Rezoning Transportation Analysis

Petition Number: 2020-200

General Location Identifier: 14510317 and 14510318

Revision Log:	Date	Description
	12-28-2020	First Review (KP)
	01-21-2021	Second Review (KP)
	02-18-2021	Third Review (EL, KP)
	03-24-2021	Fourth Review (KP)

RZ-1.0

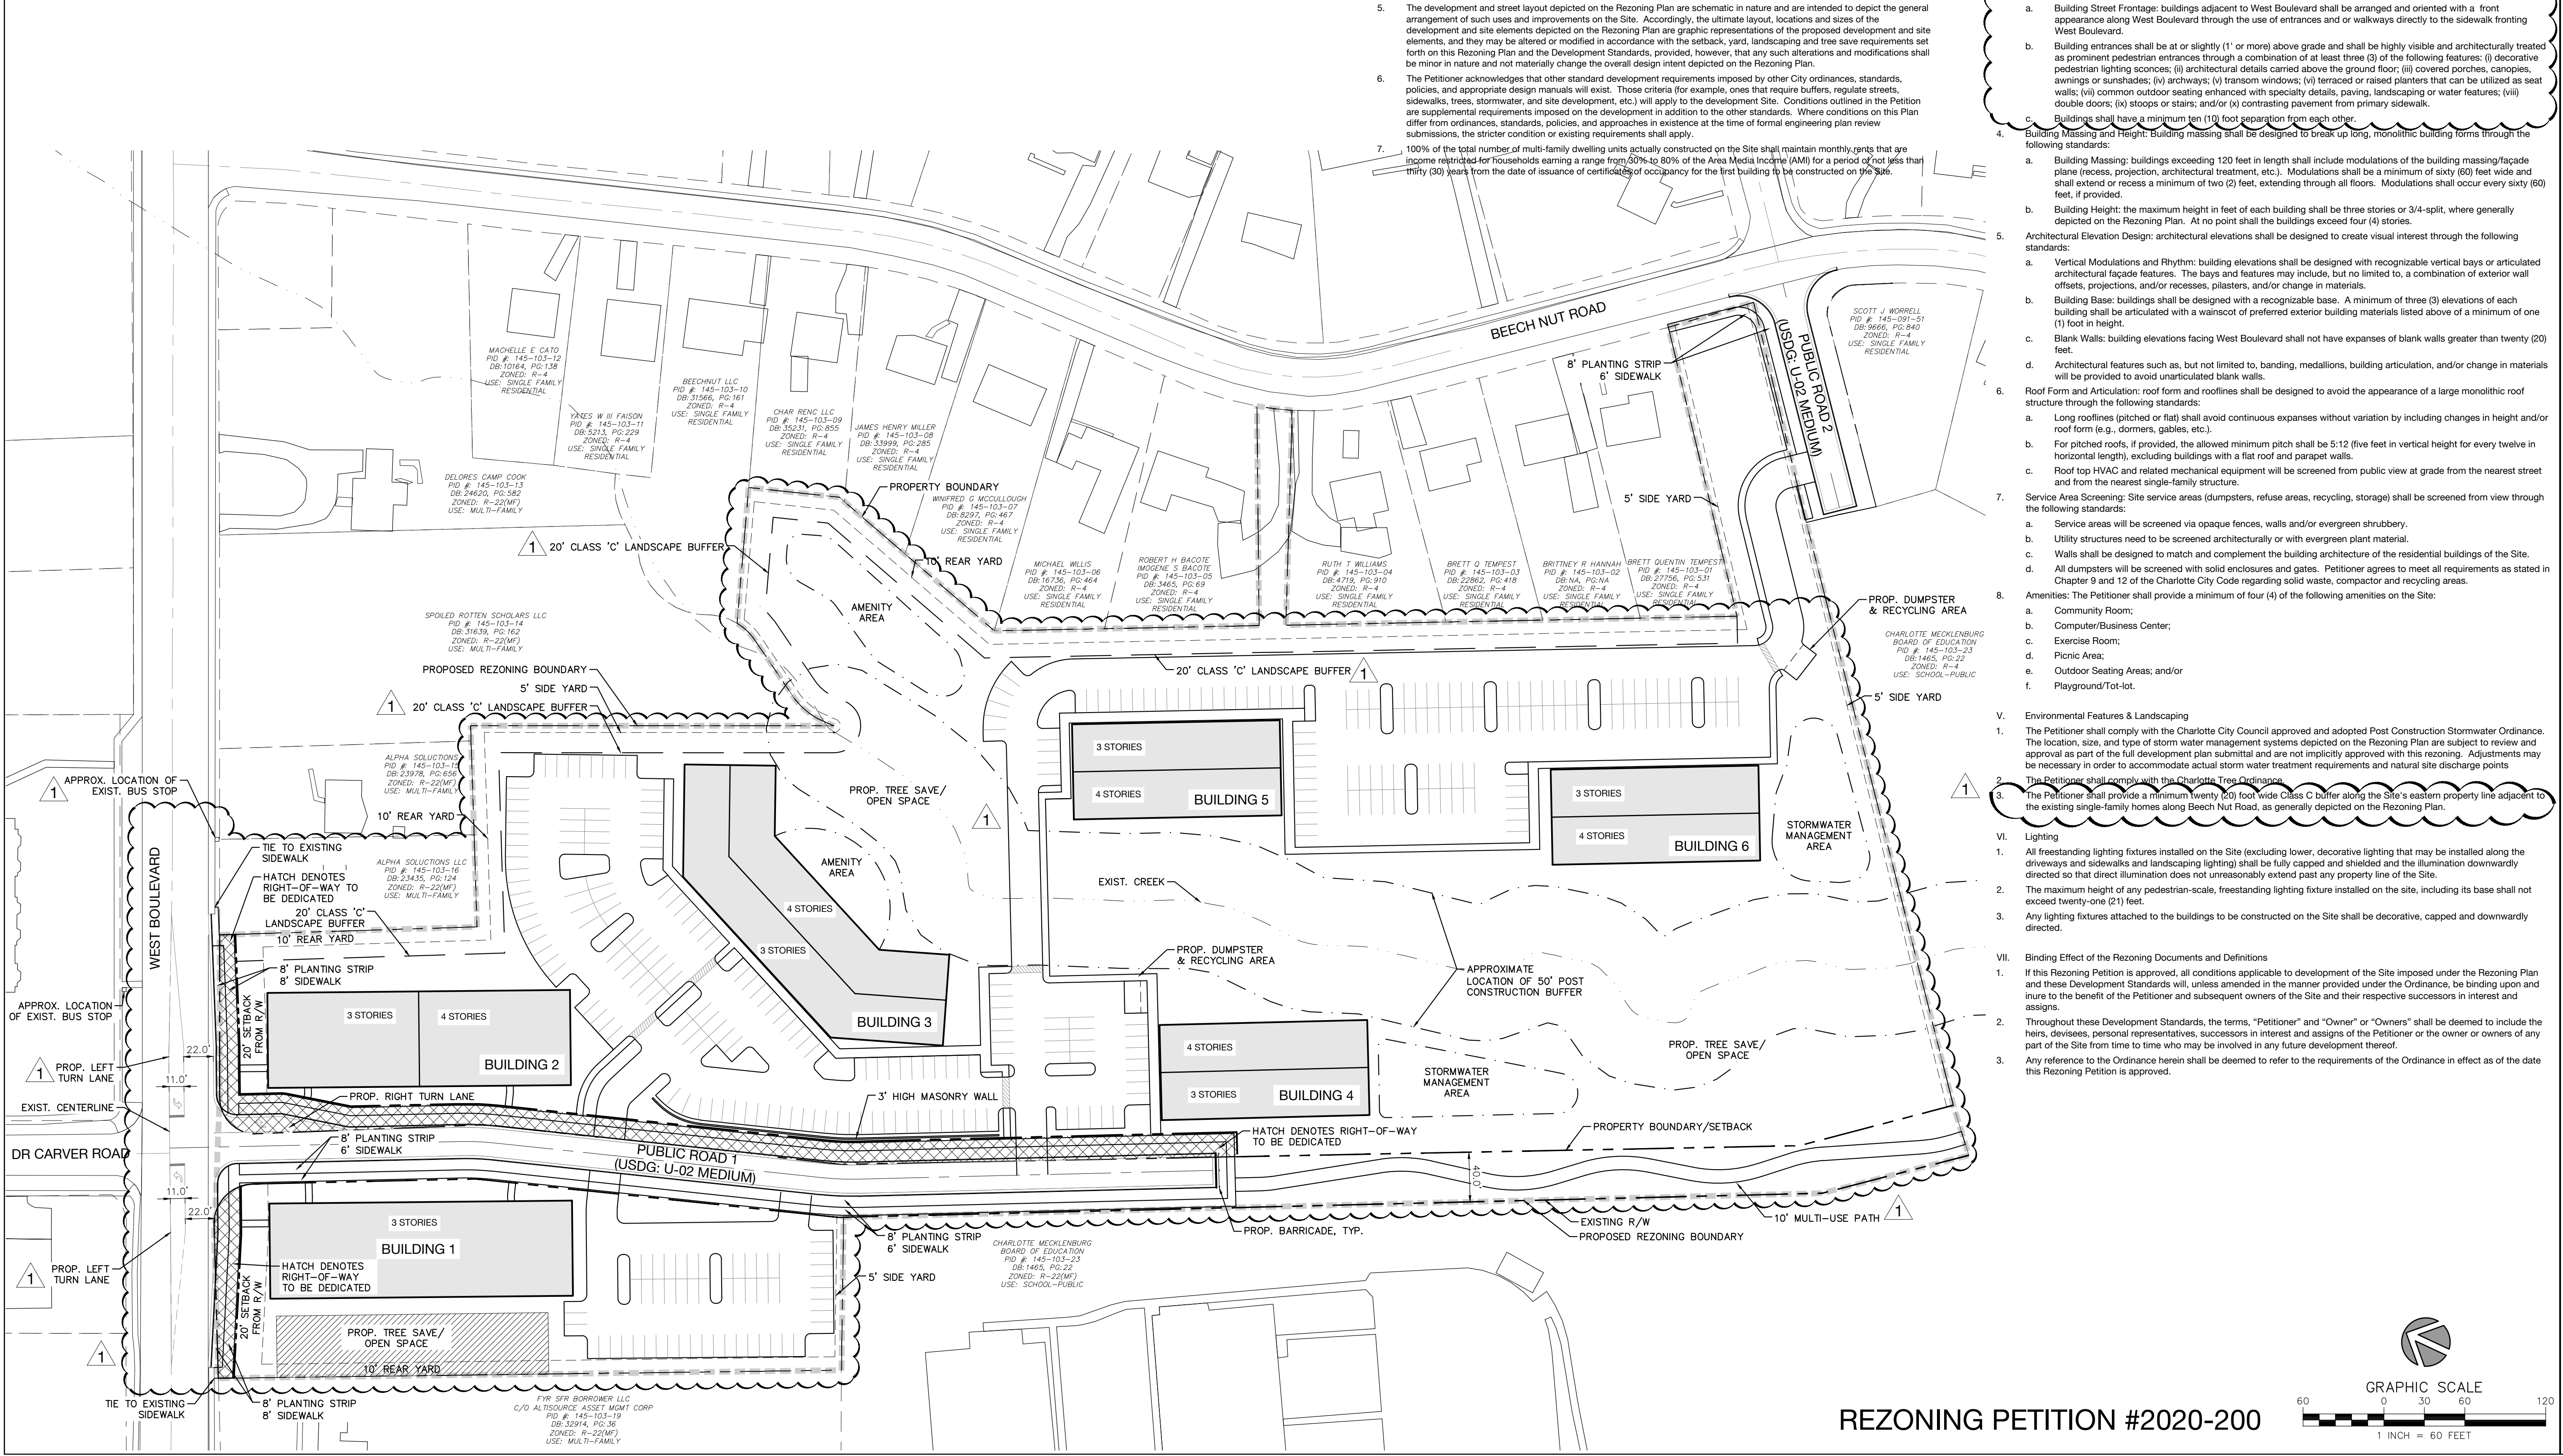
Site plan revisions are needed to address the outstanding items including, but not limited to, constructing appropriate turn lanes on the proposed access drive and clarifying language in the conditional notes. Further details are listed below.

9. **Outstanding comment (02/12/2021 Site Plan):** Revise the site plan and conditional notes by committing to coordinate with Charlotte-Mecklenburg Schools (CMS) to provide a pedestrian connection/access to the Irwin Creek Greenway. The ICG currently has a trailhead located within the adjacent property of the Berringer Academic Center.

Update to Comment (01-12-2021 Site Plan): Include the conditional note to coordinate with CMS to make the connection to the Irwin Creek Greenway Trailhead.

10. **Outstanding Comment (site plan dated 02-12-2021):** Revise the site plan and conditional notes by committing to coordinate with CATS, during permitting, to make improvements to the existing bus stop on West Boulevard. The site plan needs to show the existing bus stop.

13. ~~Outstanding Comment (01-12-2021 site plan):~~ Revise the site plan and conditional notes to commit to restriping the existing crosswalk, the Dr. Carver/Public Road 1 and West Boulevard intersection, in addition to the turn-lane and signal improvements.

14. ~~New Comment (02/12/2021 Site Plan):~~ Please clearly indicate the limits of right-of-way abandonment. Will the entire access drive off of West Boulevard be private? I would recommend shading the areas of proposed abandonment.

15. ~~New Comment (03/23/2021 Site Plan):~~ Revise the site plan by renaming Public Road 1 to "Private Access Drive". Additionally, revise each relative conditional note by changing "Public Road 1" to "Private Access Drive". Lastly, since all public roads have been removed, revise the conditional notes by removing any references to "Public Road 1".
